From: Anita Gardner
Sent: 24 December 2018 10:33
To: Planning.Responses
Subject: FW: LU/328/18/PL 90/91South Terrace, Littlehampton
Attachments: 955_LANDSCAPE SCHEME REV A.PDF

From: Anita Gardner [REDACTED]
Sent: 04 December 2018 11:44
To: Edmund T. Green <[REDACTED]>
Subject: LU/328/18/PL 90/91South Terrace, Littlehampton

It is also apparent that the access to the roof terrace has been widened and is now visually more prominent in the street scene and adversely detracts from the Building of Character. The railings have also been deleted from the proposal and these made a positive contribution to the character of the area. Accordingly, without prejudice, these items should be amended/included within the submitted scheme.

Drawing Number:	955_90ST_D104	Revision:	*
Scale:	1:100 @A3	Date:	MAY 2018
		Drawn:	ETG

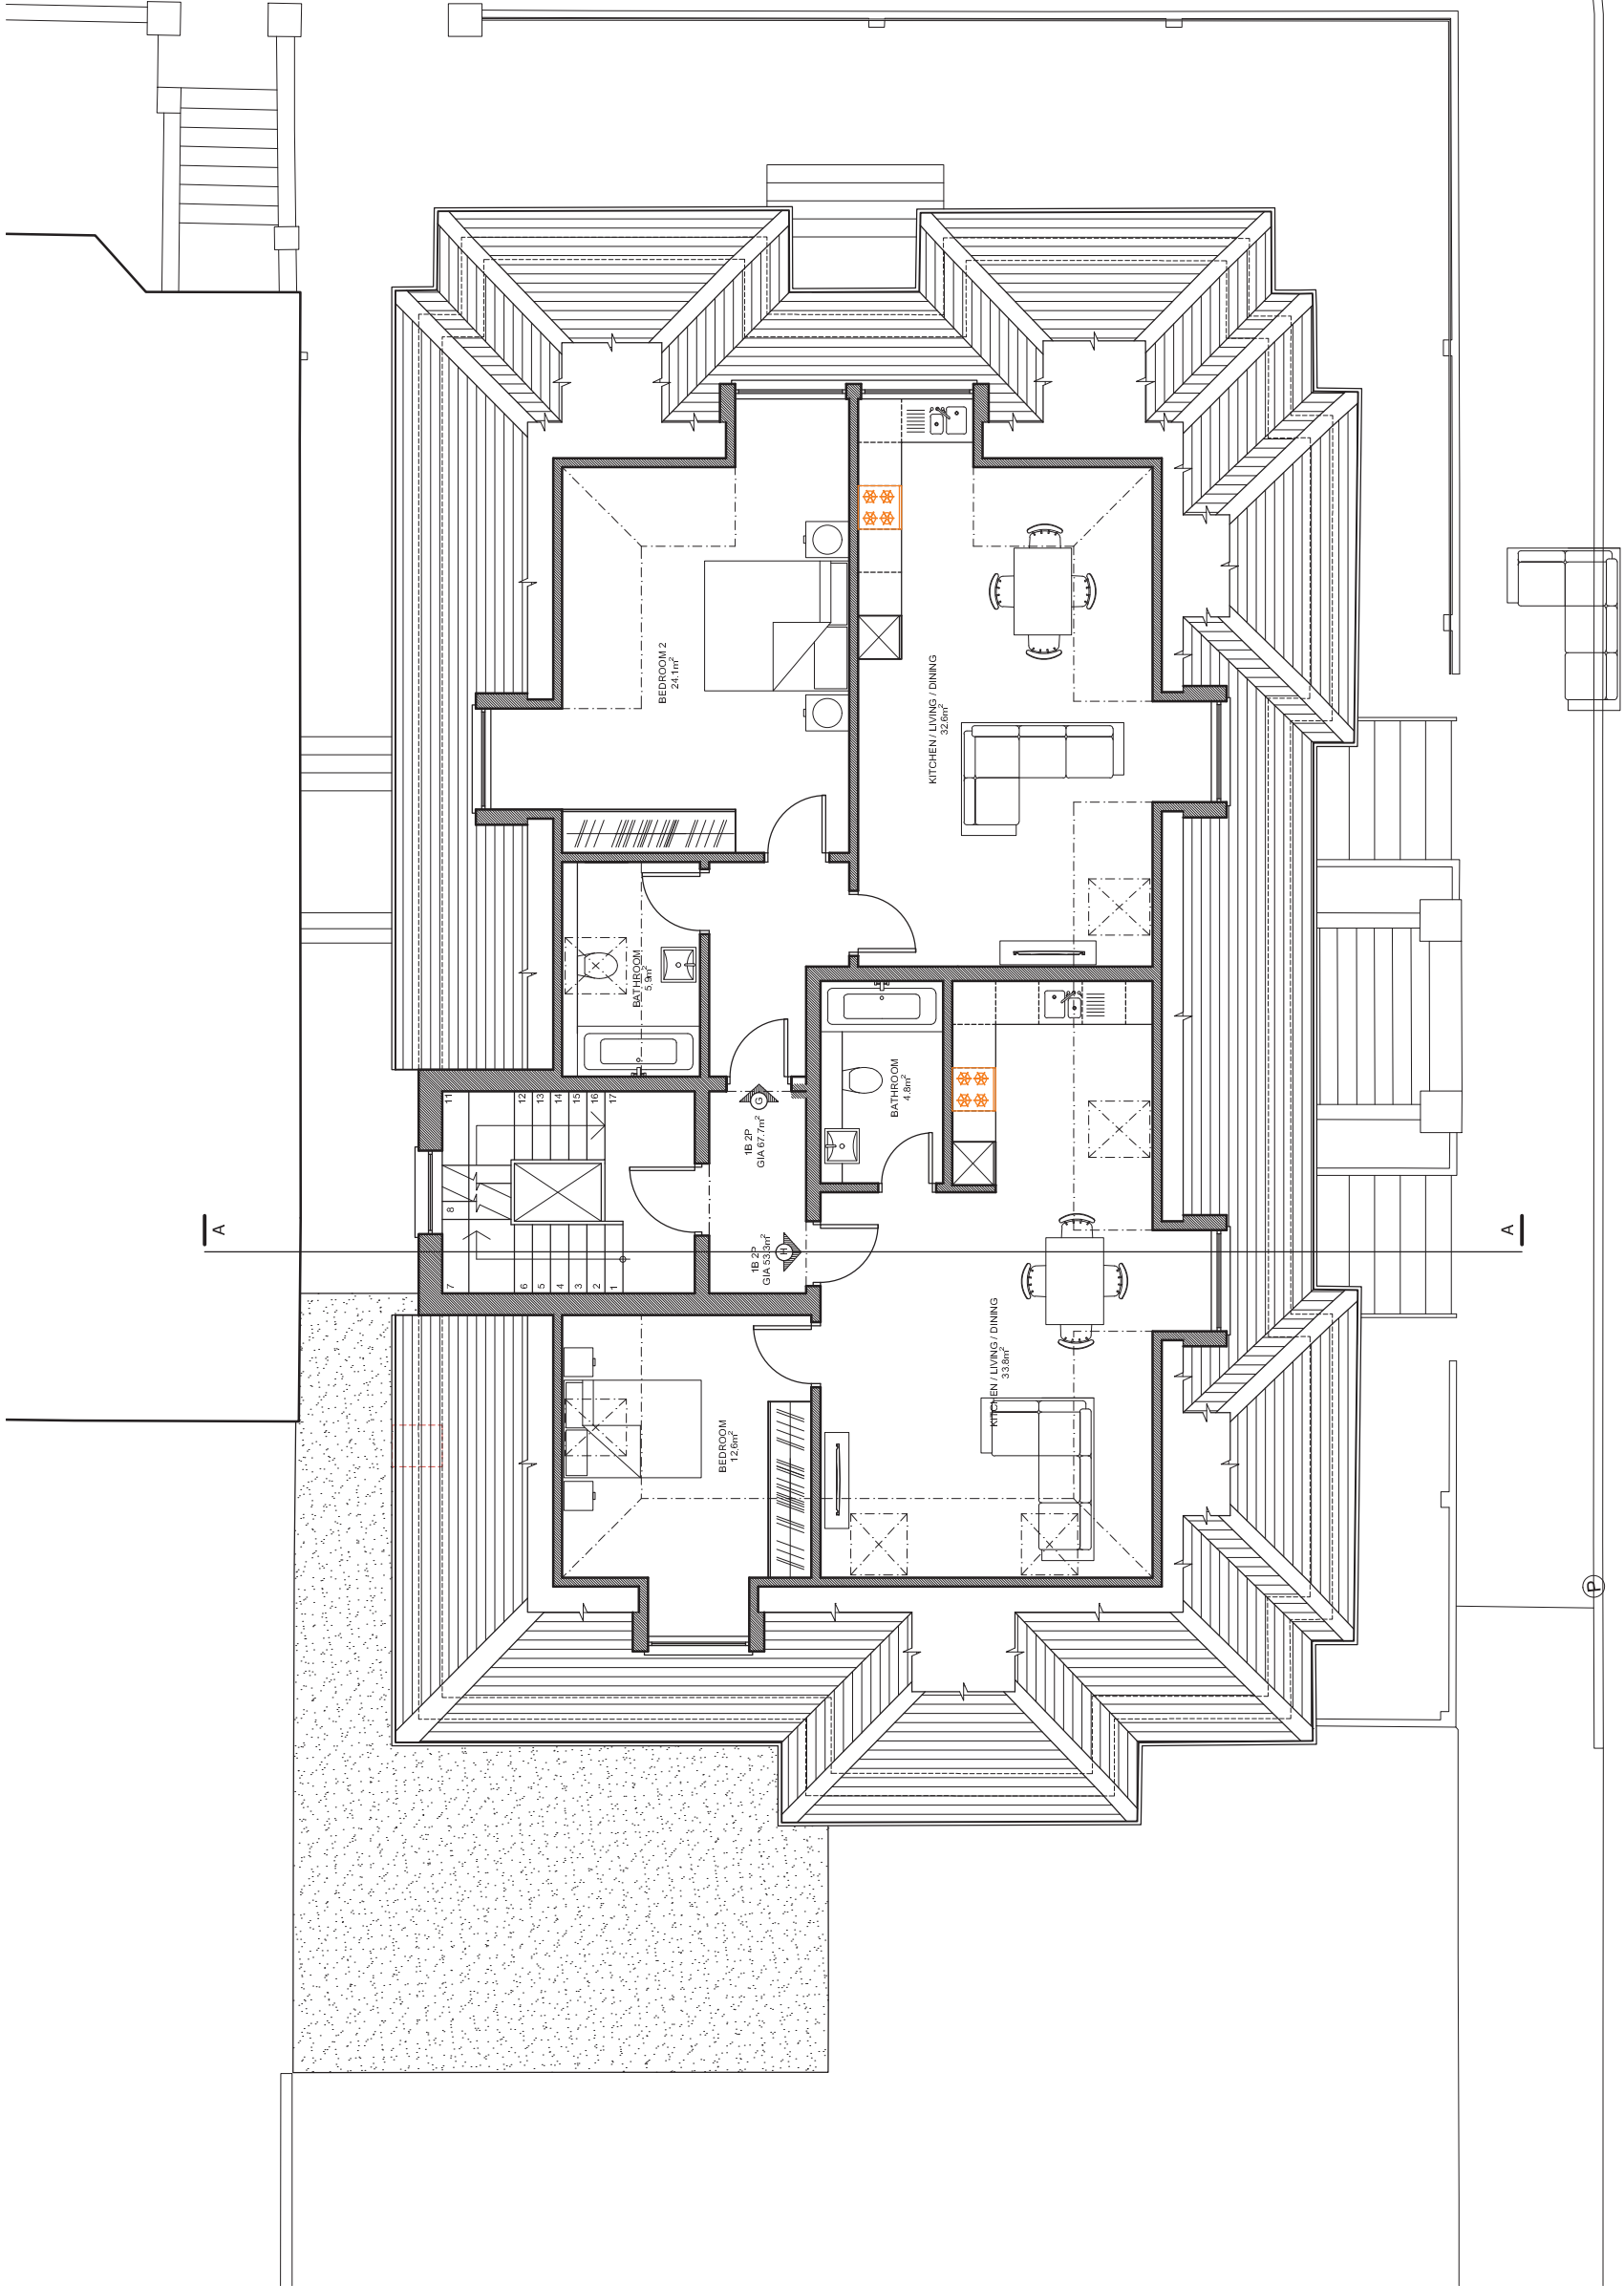
It is noted that the North Elevation Proposed 955_90ST_x010 is incorrectly titled and should read Existing North Elevation and the Second Floor Plan refers to the bedroom to Flat G as the second bedroom when it is the only bedroom.

Please find the amended drawings attached showing the drawing title/labelling errors corrected - thank you for drawing these to my attention.
